Your Ref: EP/87/13/DOC

16 August 2013

Article 21 of the Town and Country Planning (General Development Procedure) Order 1995
Application to discharge conditions 4 and 5 imposed under planning consent EP/47/13 -
Landscaping scheme & construction activities
51 Angmering Lane East Preston,,

PROPOSED LANDSCAPED SITE PLAN			
51 Angmering Lane, East Preston, West Sussex BN16 2TA			
CLIENT		Mr & Mrs Keyse	
Issue	Details	By	Date
SCALE	AS SHOWN on A3		
DATE	10/07/13		
DRAWING NUMBER	12026/02L

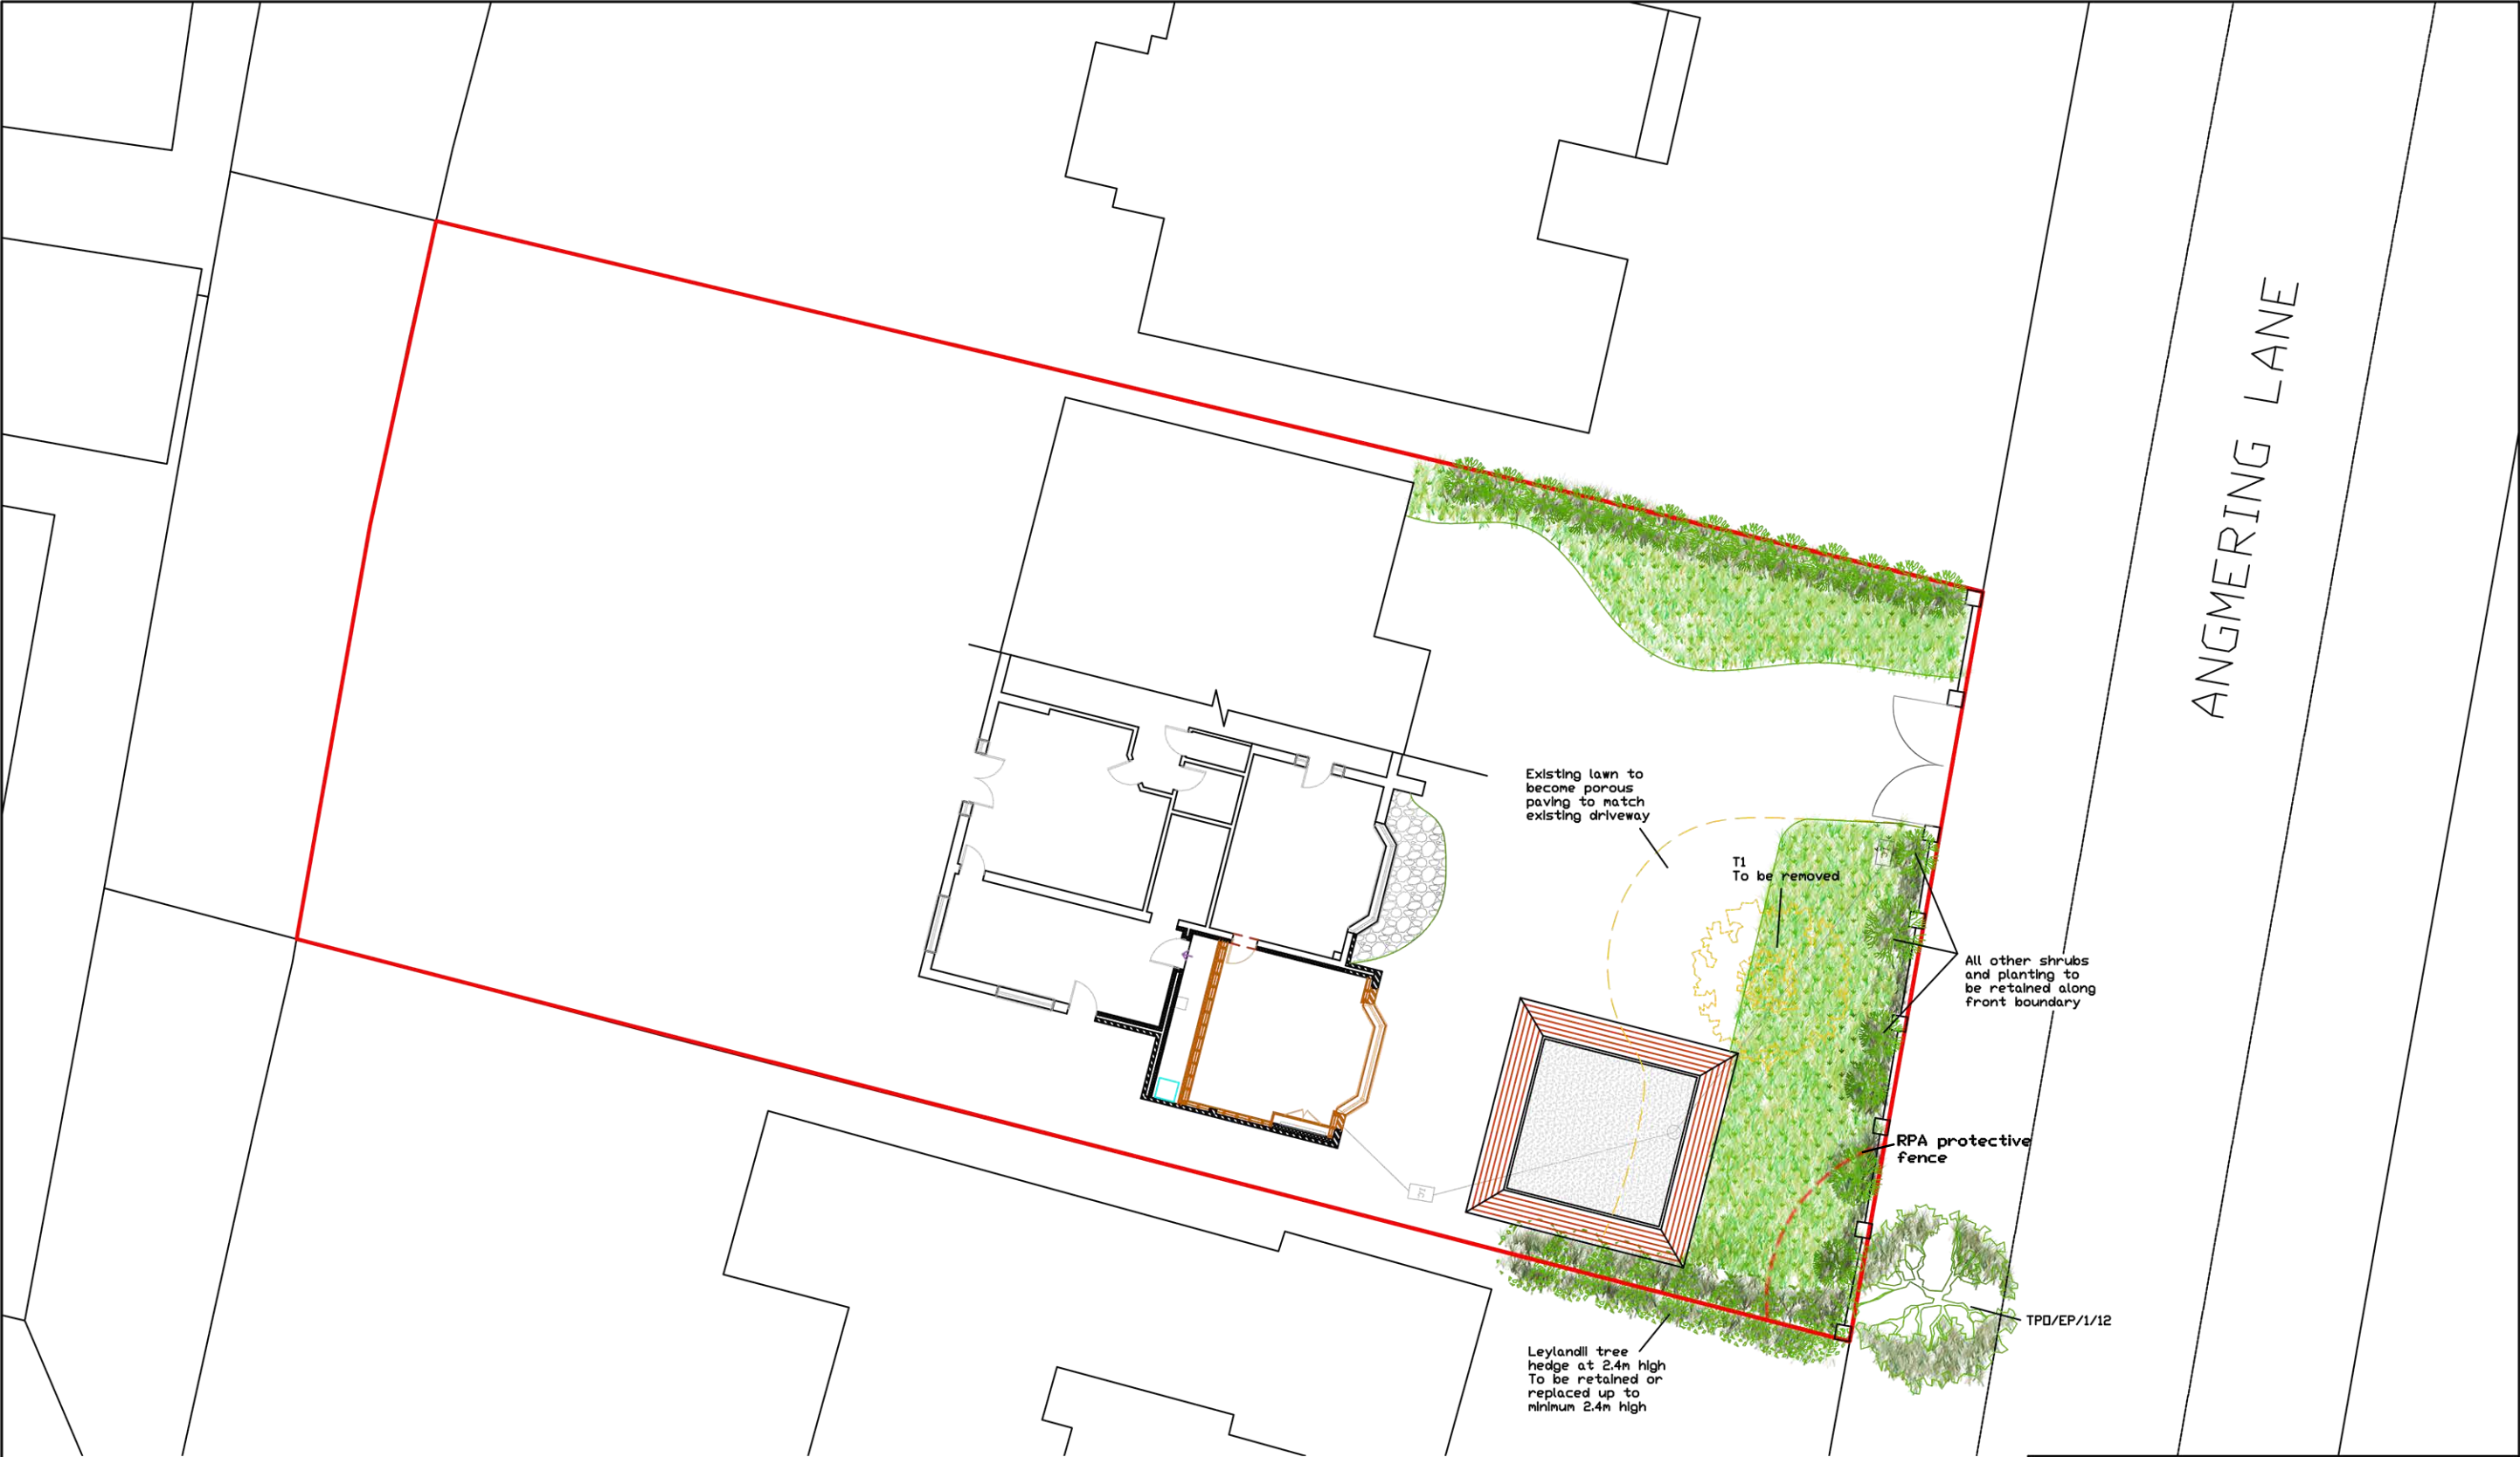
Drawing no 12026/02L does not refer to any additional shrub planting to screen the development along the site frontage in front of the garage or along the front portion of the southern boundary as required by the condition.
